DECISION DELEGATED TO HEAD OF PLANNING

Application No:	H05-0985-24	Applicant:	Mr & Ms S O'Neil
Proposal:	Change of use of previously reclaimed land to enable a mixed residential and equine use to include two residential static caravans and two touring caravans and erection of two stables and ancillary works to create a home for a Gypsy / Traveller family		
Location:	Land To West Of Langary Gate Road Fleet Coy Spalding		
Terminal Date:	4th June 2025

TF3312SW

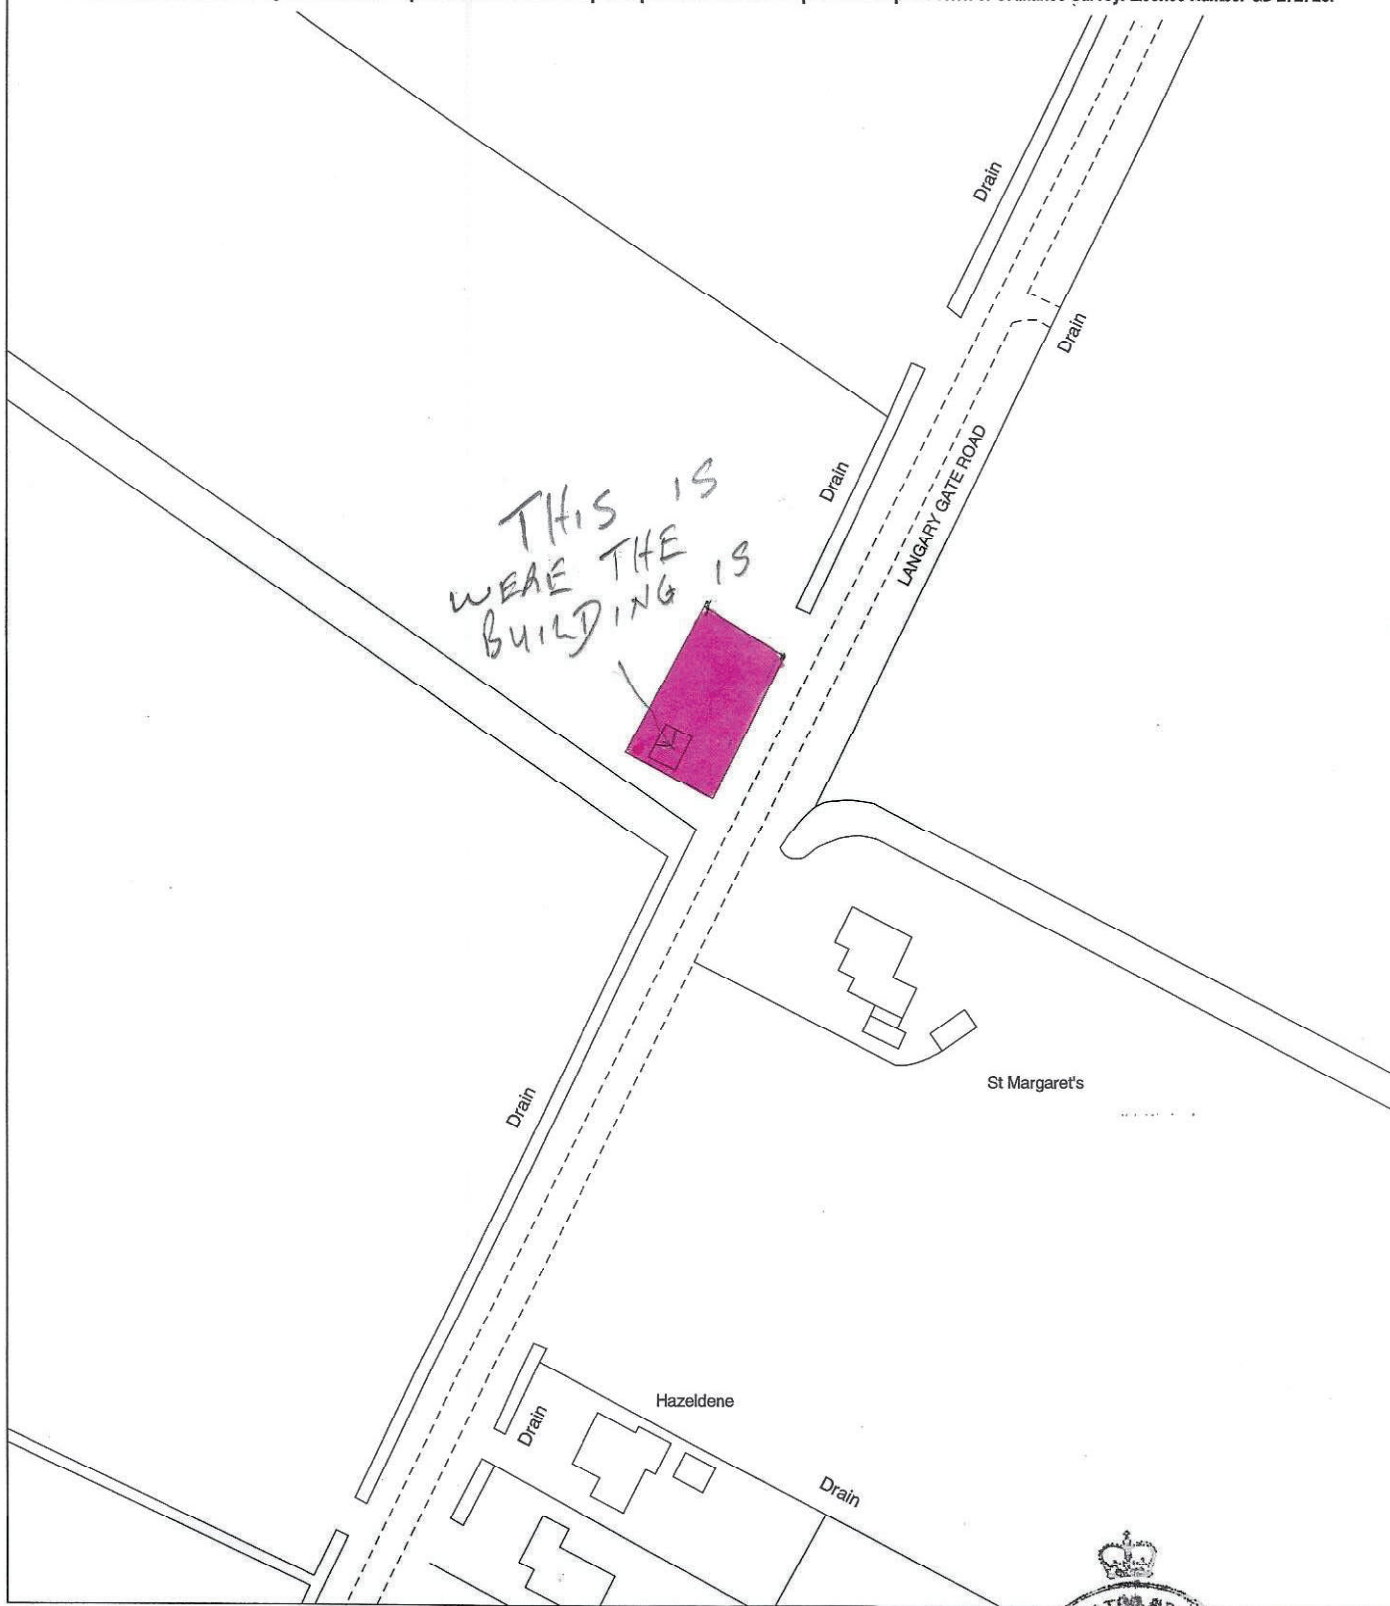
Please be aware that the Board owns a section of land to which this application relates and has neither been given the requisite notice required nor is the Board listed in Certificate B of the Application Form. The site boundary line must be adjusted landwards as per HM Land Registry

plans. Specifically, at the northern boundary the Location Plan (submitted 22/11/24) shows the site outlined red extending from the top of bank and down the batter to the landward toe of the 'Drain'. This land belongs to the Board (Part of Lambert Drain and Fleet Drain and Main Road Drain, Holbeach Spalding, known operationally as E31 Lambert Drain Connection).
